Project #: 100787Z Application #: 12.DRB-703231
Project Name: Plat of Tract 3A-1 Pavillions at San Mateo
Agent: Terra West LLC Phone #:

3. **Project# 1007872**
12DRB-70324 EPC APPROVED SDP
FOR BUILD PERMIT
TIERRA WEST LLC request(s) the above action(s) for all
or a portion of Tract(s) 2A-1, **PLAT OF TRACT 3A-1**
PAVILIONS AT SAN MATEO zoned C-3, located on
SOUTH SIDE OF CUTLER BETWEEN SAN MATEO
AND WASHINGTON containing approximately 3.85
acre(s). (H-17) **THE SITE PLAN FOR BUILDING PERMIT**
WAS APPROVED.

Project# 1007872
12EPC-40049 Amend Site Development Plan for
Building Permit

SHEET C1

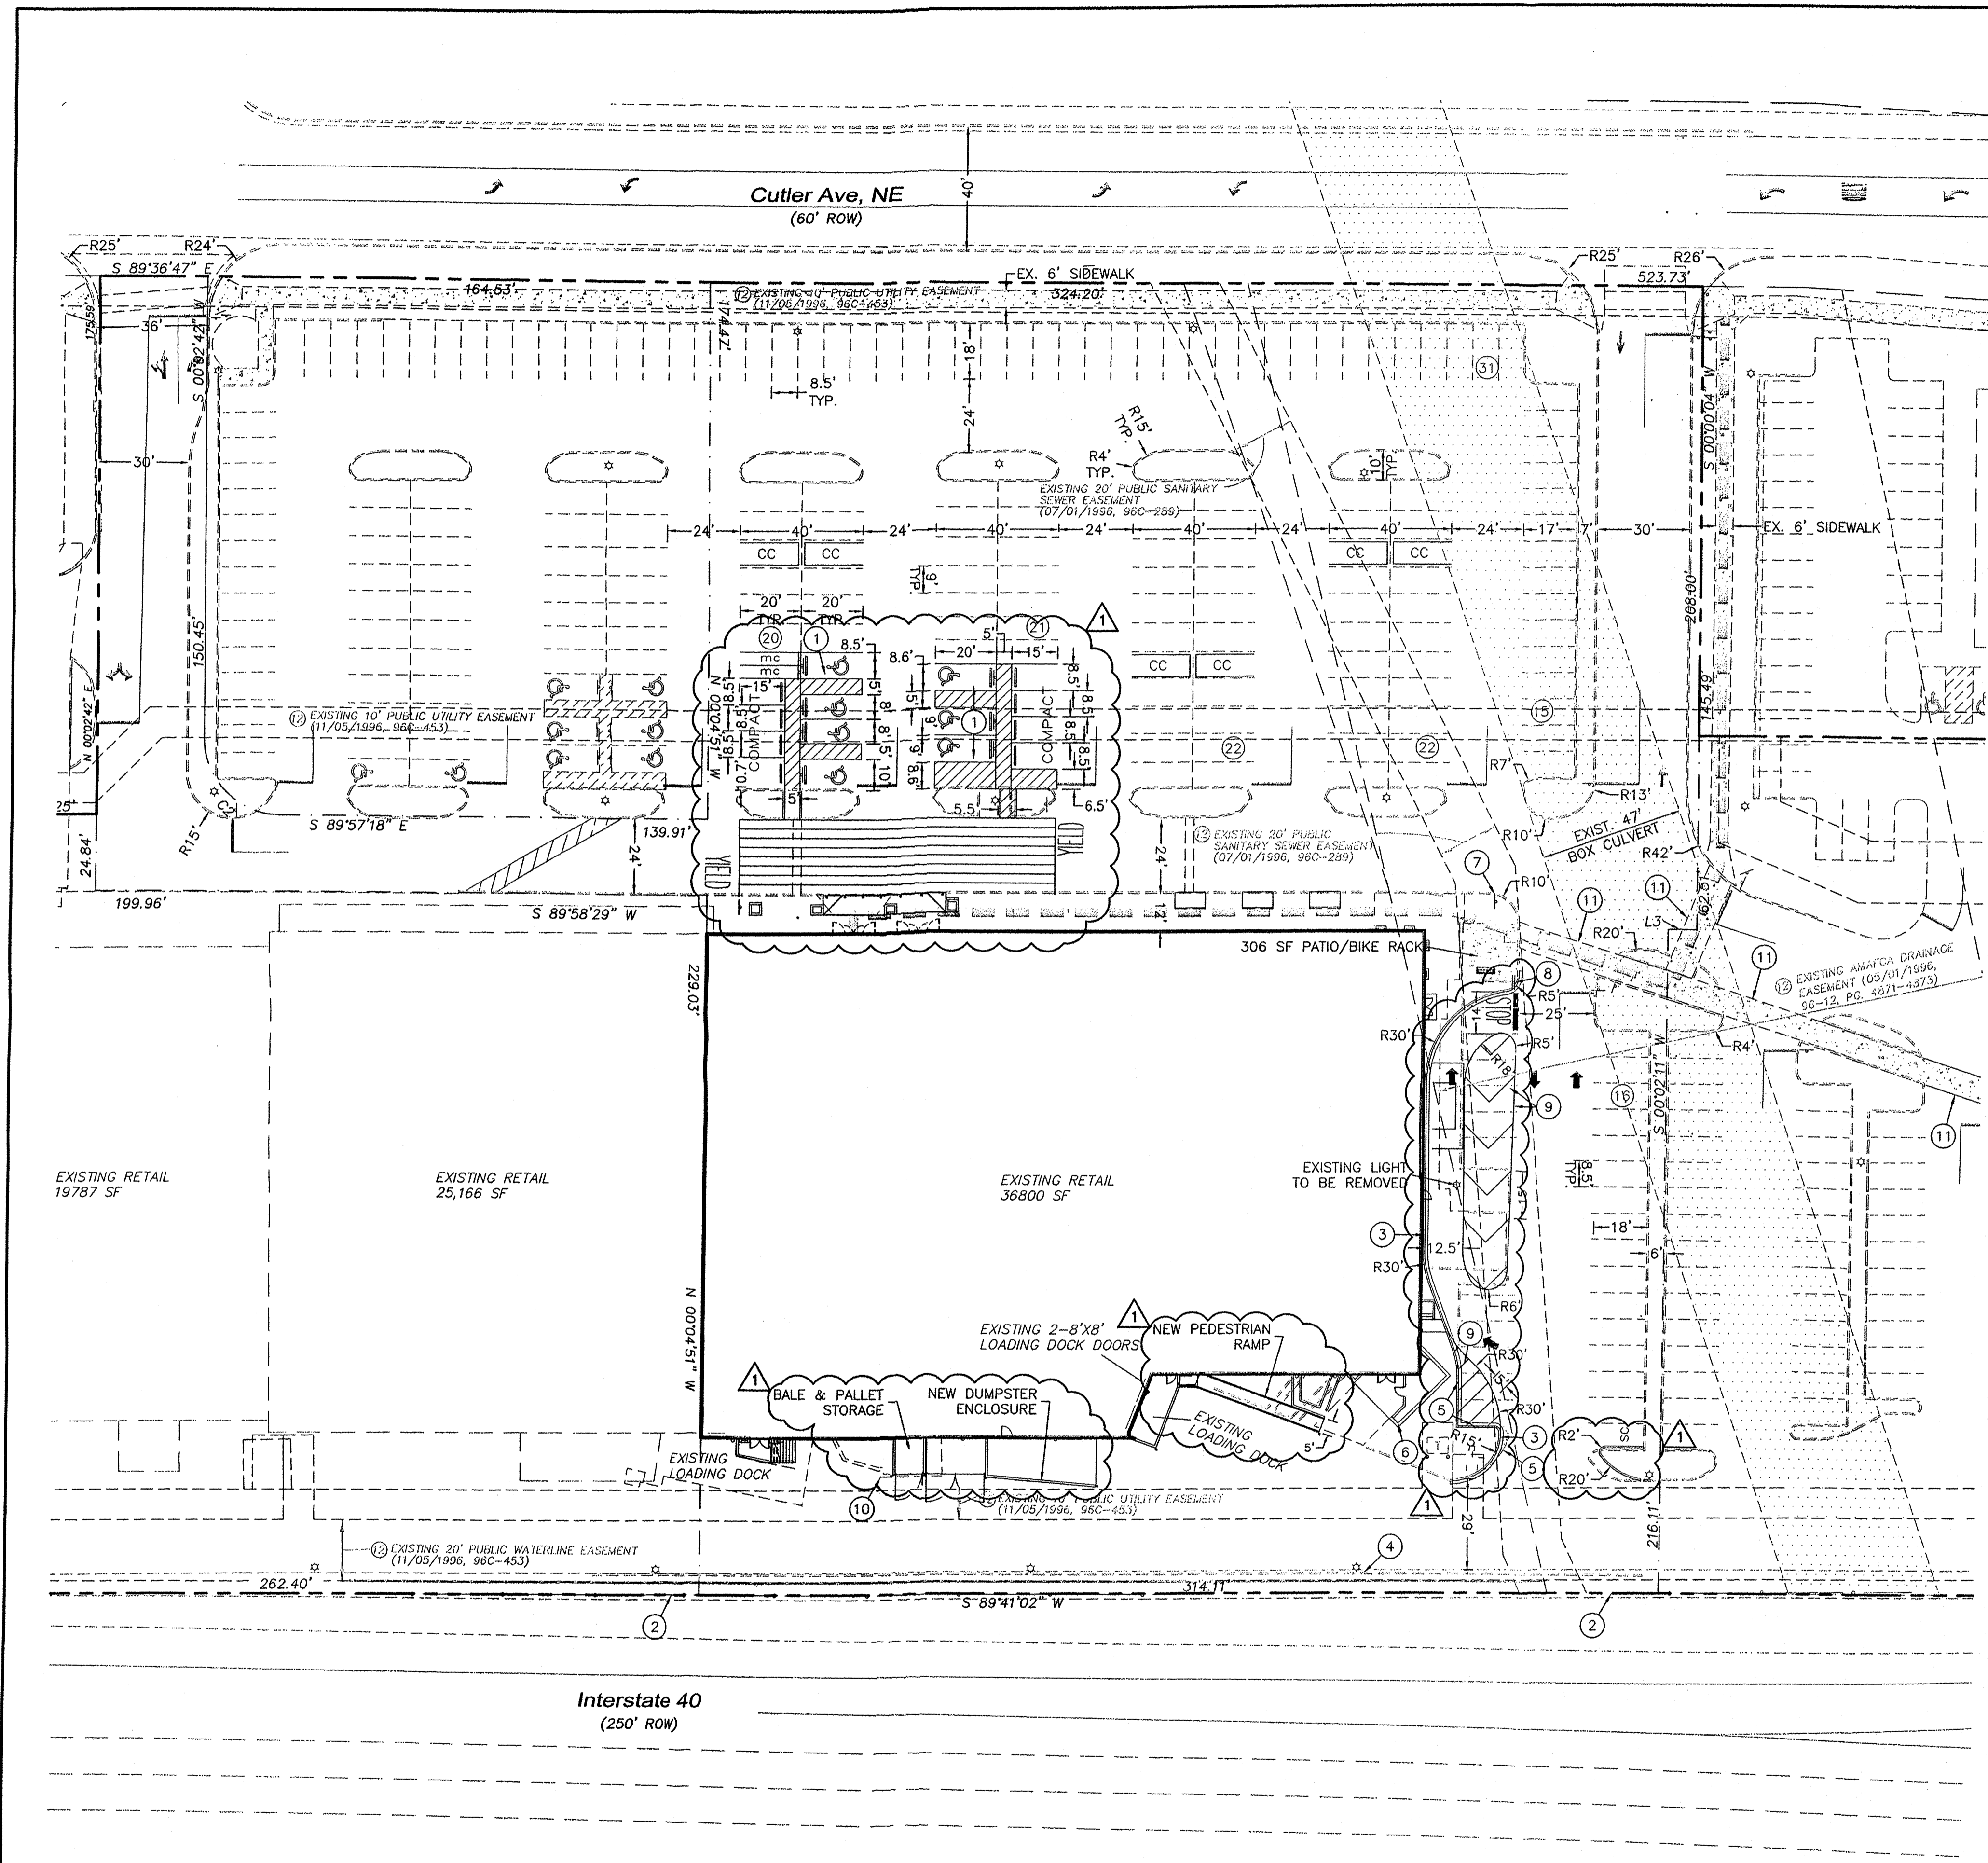
5. Sheet C-1 shall be modified, in the appropriate sections, to indicate the change to indicate the correct number of parking spaces, compact parking spaces, motorcycle, and handicap accessible parking spaces provided. These changes shall be marked with a cloud and the "Delta 1" symbol.

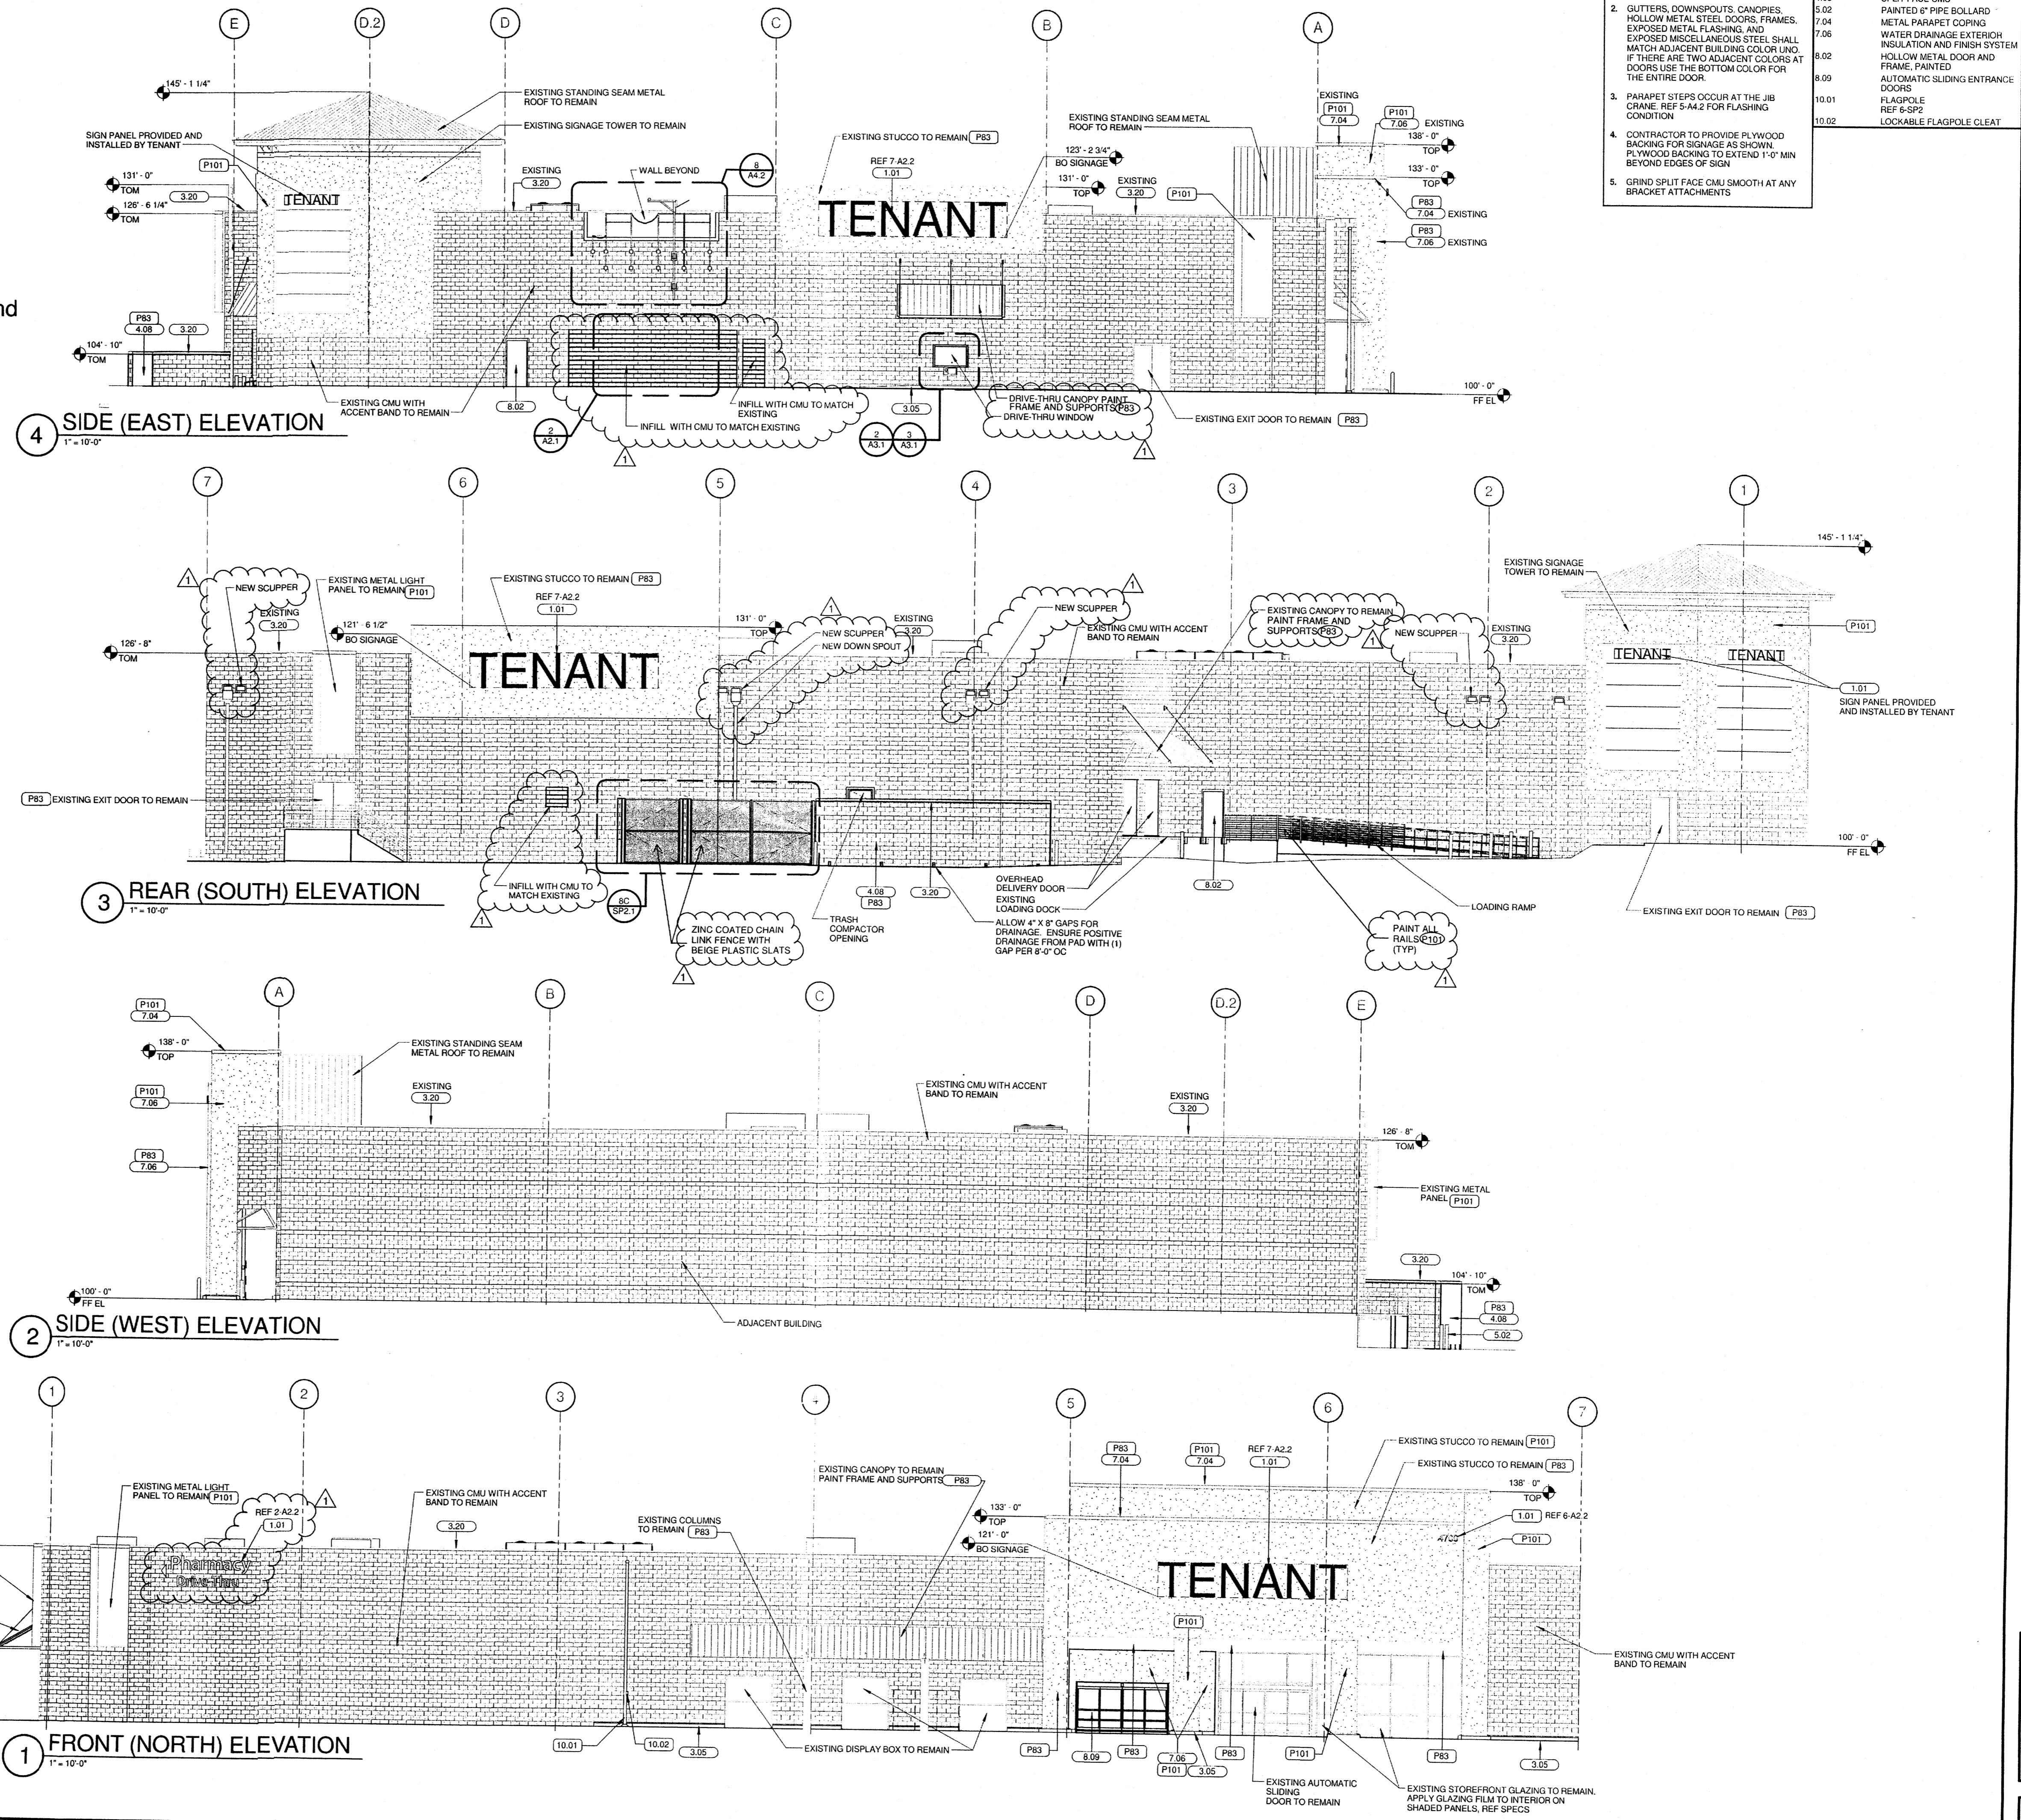
6. Sheet C-6 shall specify the material and color for the hand rail at the loading ramp, the existing and proposed canopies, and dumpster enclosure doors. The colors shall be compatible with the proposed brown and camel stucco and the grey and camel metal storefront elements.

7. Sheet C-6 shall identify the new sign proposed on the north building façade with a cloud and the "Delta 1" symbol. The sign face size shall be calculated and added to the Building Signage Schedule.

8. Sheet C-6 shall identify all changes to the façade, including multiple instances of "new scuppers" and "infill with CMU" with a cloud and the "Delta 1" symbol. The scale shall be corrected.
